Portishead Branch Line (MetroWest Phase 1)

TR040011

Applicant: North Somerset District Council
8.1 Addendum to the Design and Access Statement

Author: Jacobs / Womble Bond Dickinson LLP
Version: 1
Date: September 2021

Drawing
PORTISHEAD STATION CAR PARK
LAYOUT, LANDSCAPING AND NEW
BOULEVARD AND ACCESS PLAN
SHEET 2 OF 3

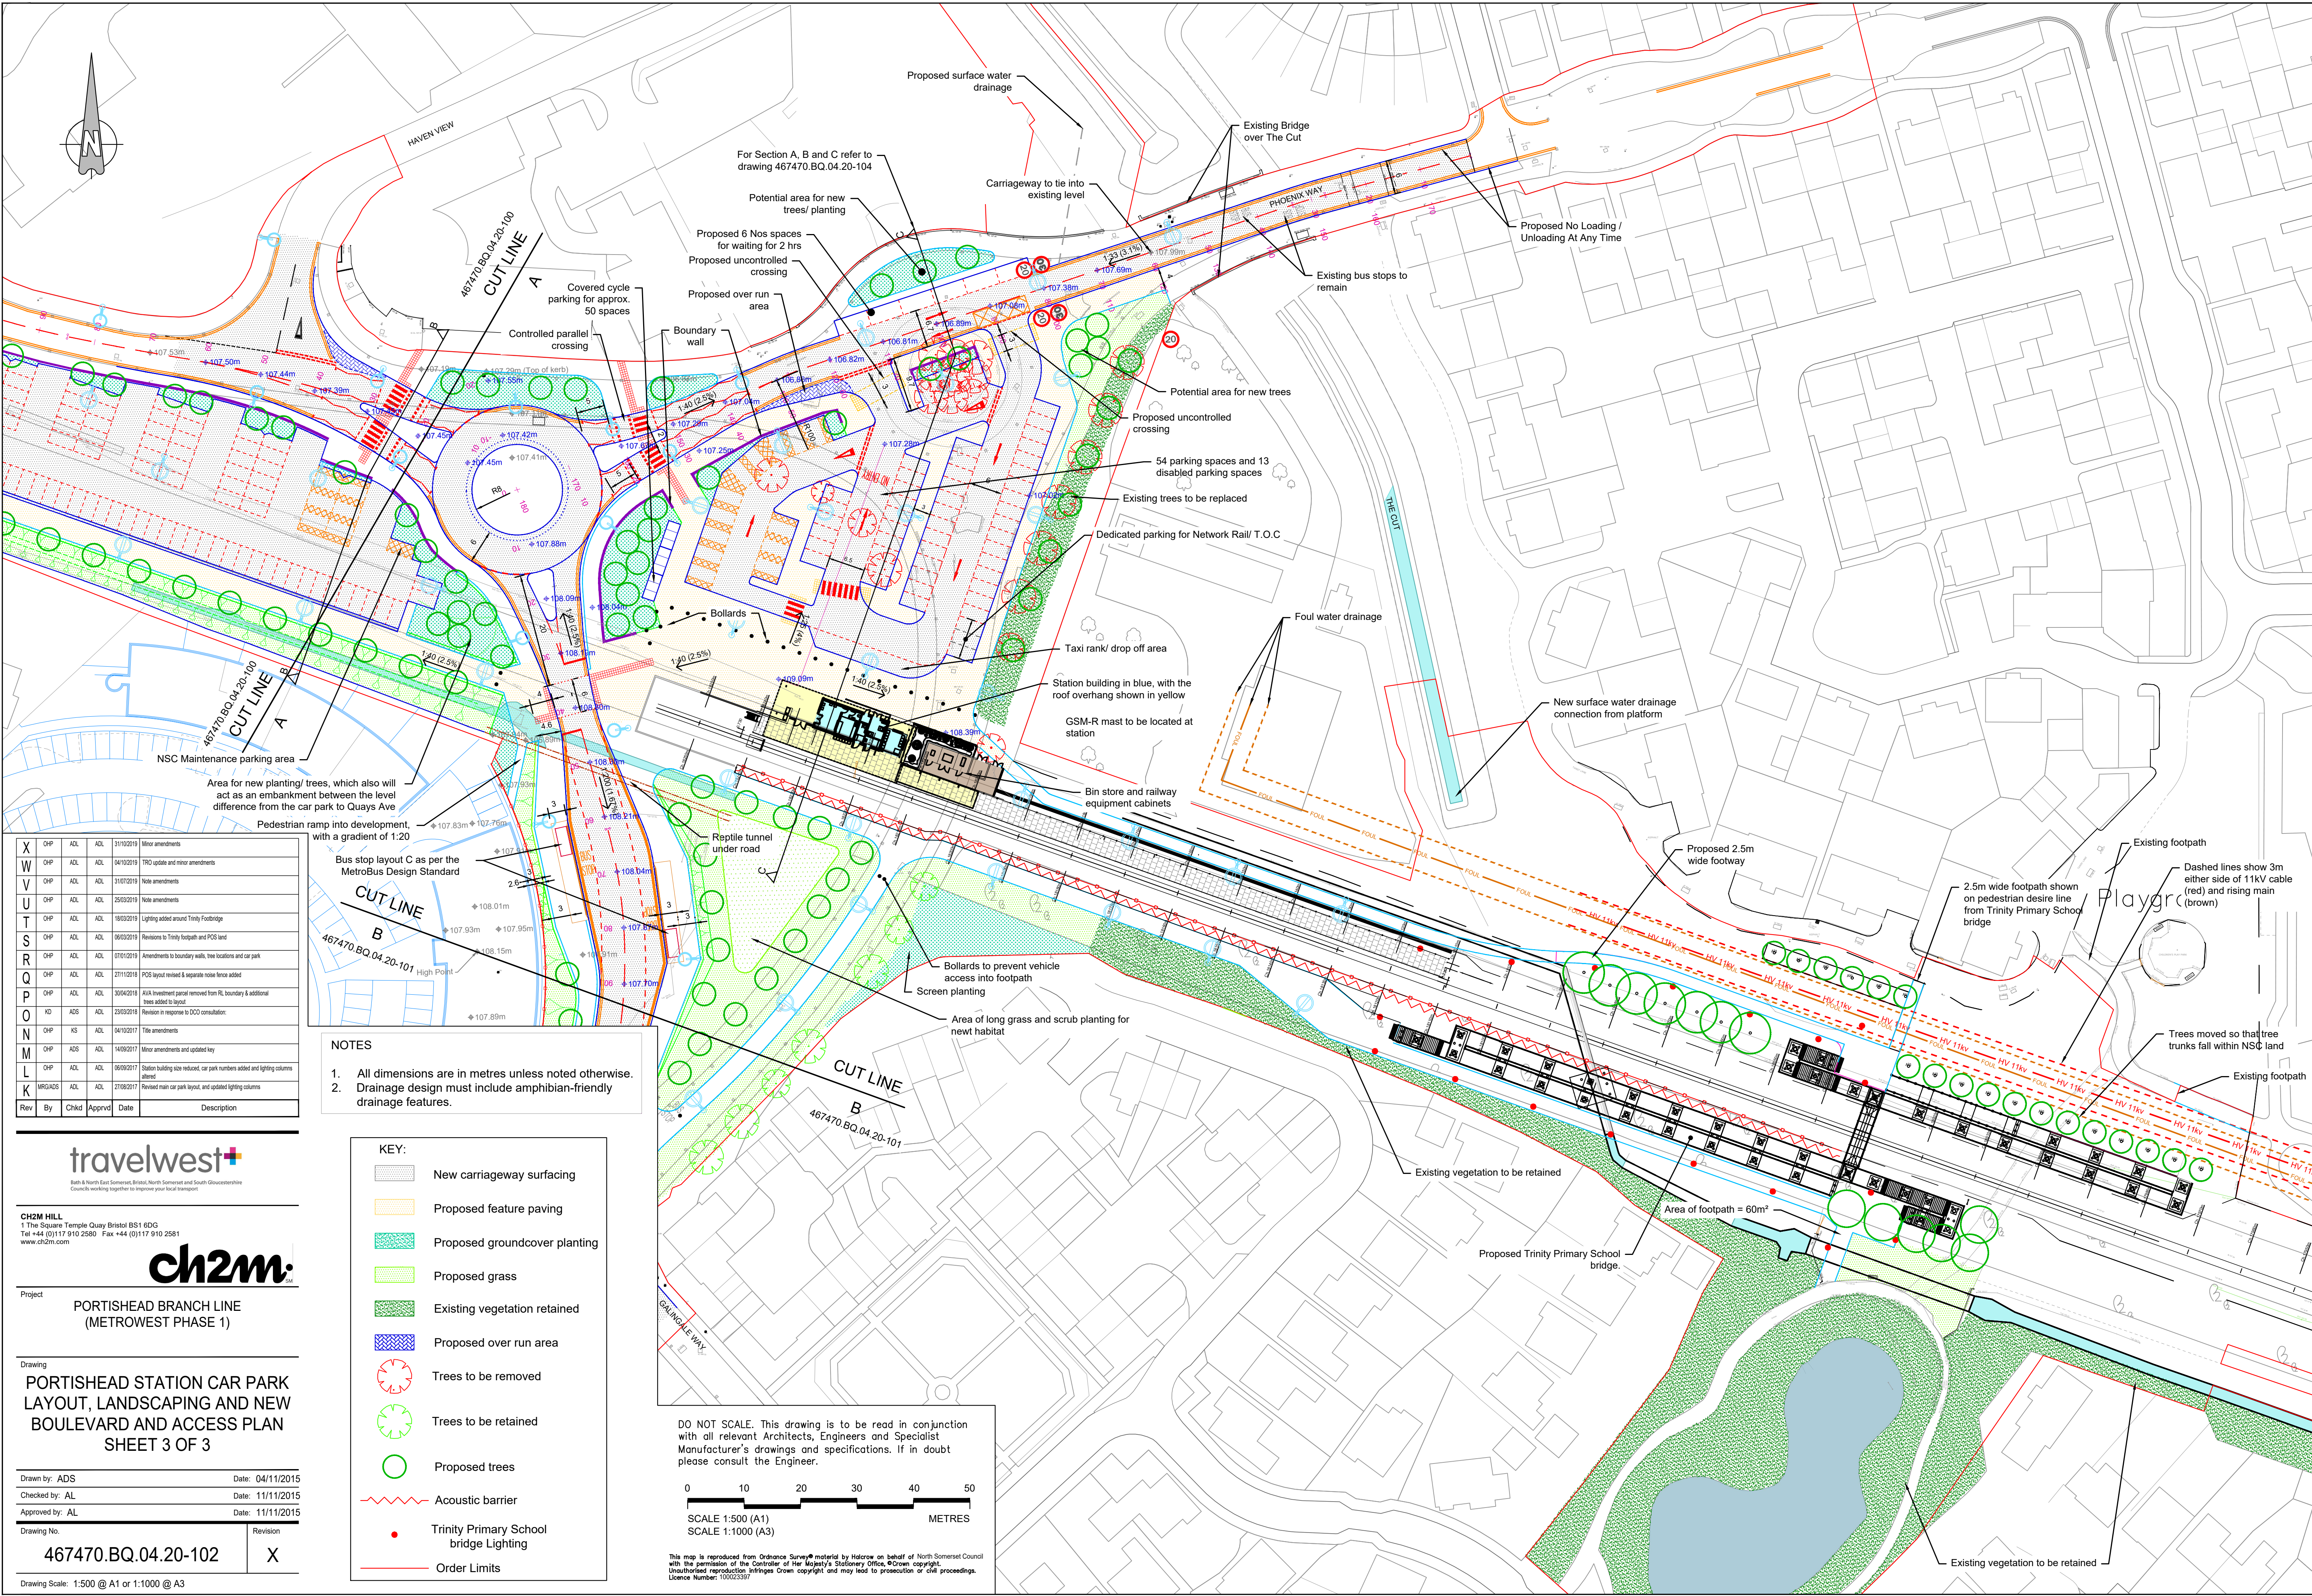
- 2.9. Paragraph 20.13 has been removed.
- 2.10. Figure 30 is replaced with the latest version of drawing 467470.BQ.04.20-100 rev AA.
